Our ref: SSD-70316465

Subject: Request for Additional Information

I refer to the Department of Planning, Housing and Infrastructure's (the Department) letter of 13 December 2024, which advised the Department would be providing comments following the exhibition of the Environmental Impact Statement (EIS) for the proposed Burrah Park development (SSD-70316465).

Figure 4: Site plan showing the boundary of the three lots which collectively for Stage 1 (1.1, 1.2 and 3.1)

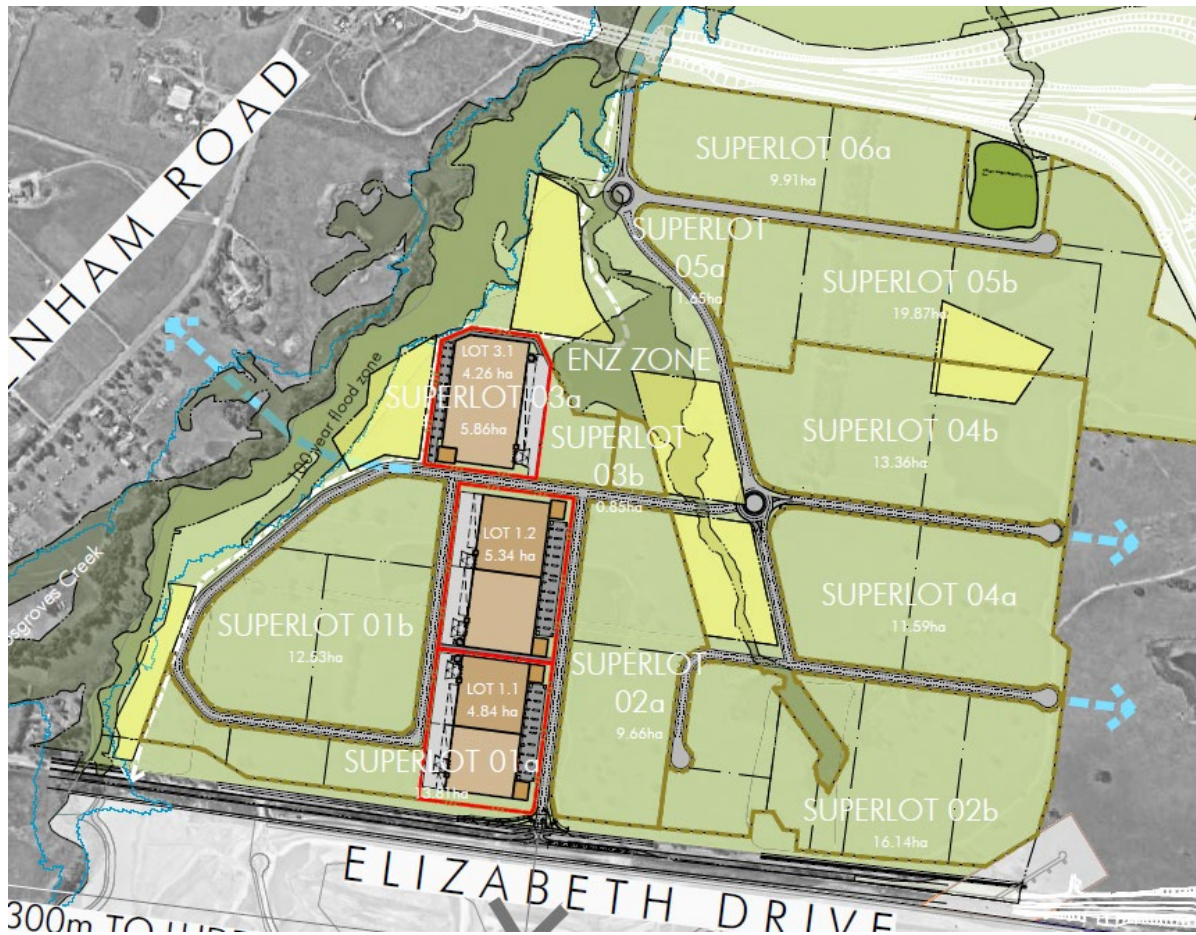
- Clarify responsibility for maintaining the fire access track/active transport link proposed between some lots. The track between Lots 1.1 and 1.2 appears to be located partly across both lots.
